**Re: 770 Brookfield Road – On-Street Parking and Loading Assessment  
1<sup>st</sup> Review – Response to City Comments**

**Subject:** *770 Brookfield Road – On-Street Parking and Loading Assessment - Revised*

770 Brookfield Road
Residential Development

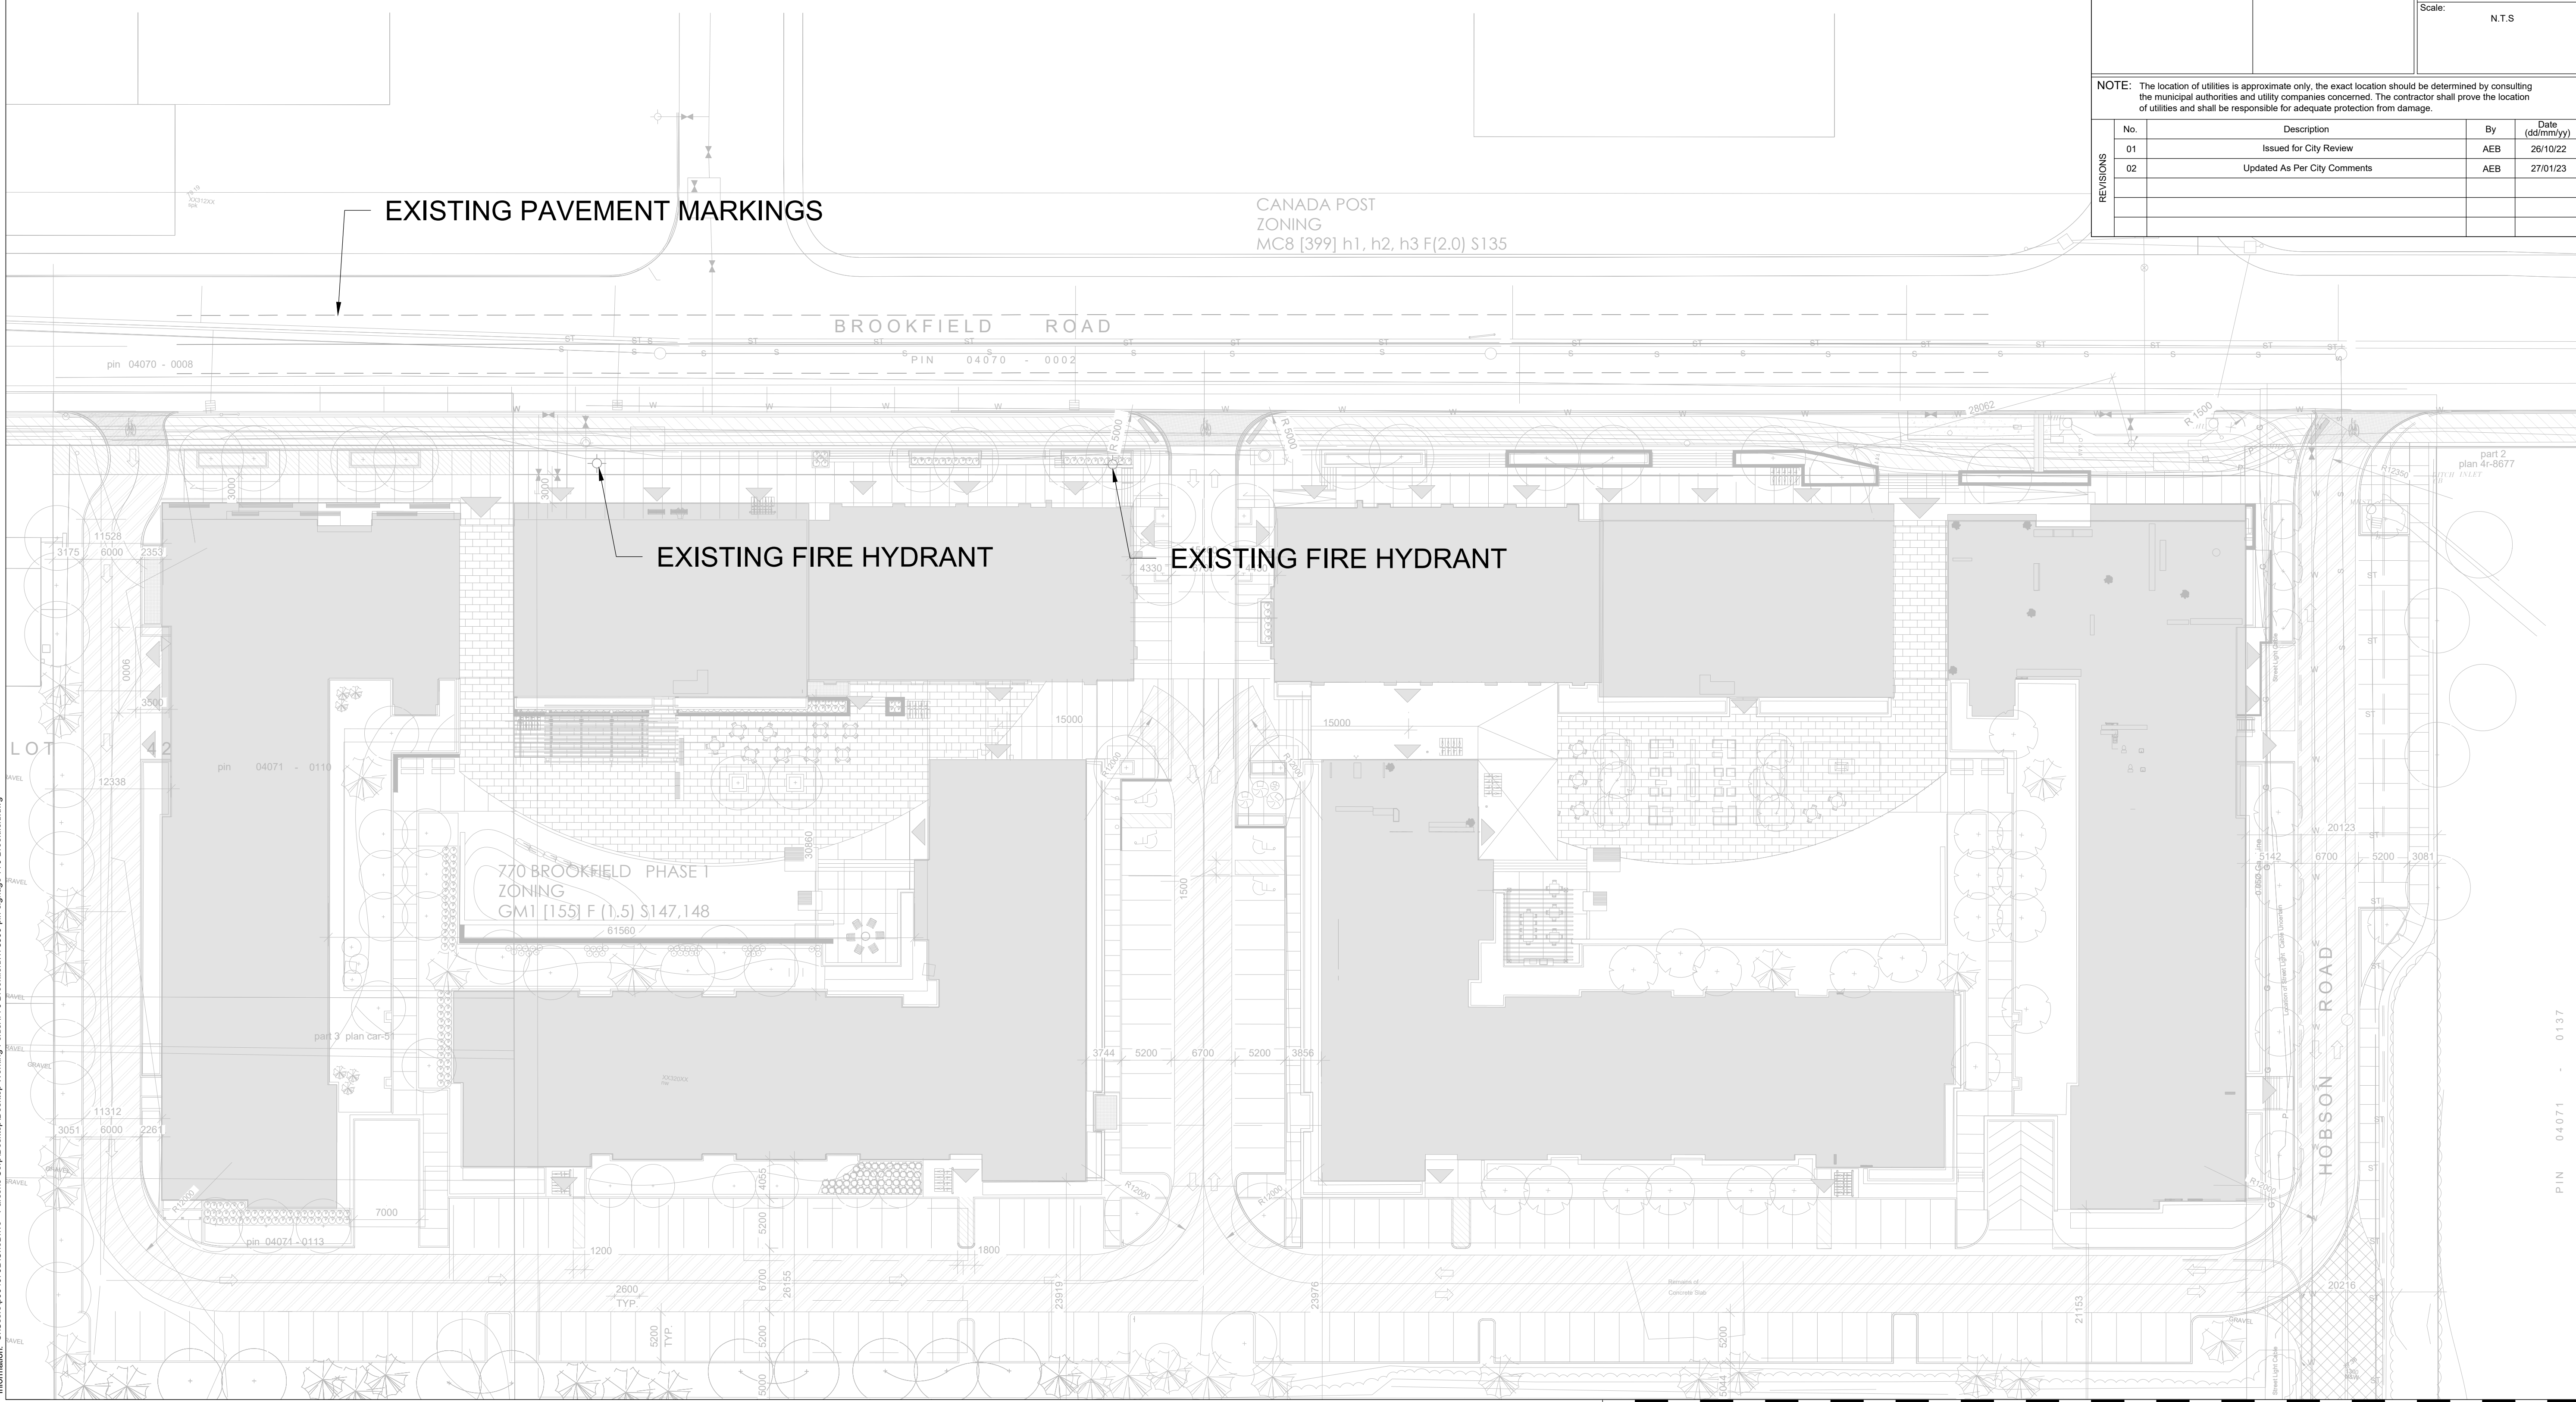
- Comment 5.** As noted, the proposed loading zones are not supported, and all Rx-521 signs should be replaced with Rb-53A signs.  
Plan revised.
- Comment 6.** Placement of signage west of the main access should be repositioned to a location that does not obstruct the staircases.  
Plan revised.

- Comment 7.** Placement of signage east of the main access is within the multi-use pathway. Per Section 4.3.5 of OTM Book 18, all signage should be installed 0.5m from the edge of the multi-use pathway (minimum 0.3m).  
Plan revised. Signage east of the access is intended to restrict parking nearest the adjacent OC Transpo stop.

- Comment 8.** Design of interaction between the multi-use pathway and the permanent location of OC Transpo stop ID: 4139 must meet Transit Services requirements.  
An on-site and virtual meeting was held with OCT to resolve the MUP-transit interaction. Plan revised.

- Comment 9.** As noted above, a minimum clear sight distance of 14m is required on either side of the site accesses. The 14m clear sight distance should be measured from the point of curvature of the curb return. Dimension this distance in the signage plan.  
Plan revised.

- Comment 10.** The existing multi-use pathway is missing pavement markings through the site accesses. Through this new pavement marking and signage plan, please add edge lines, centrelines, and stencils to the multi-use pathway within the site accesses. See schematic image below:  
Plan revised.
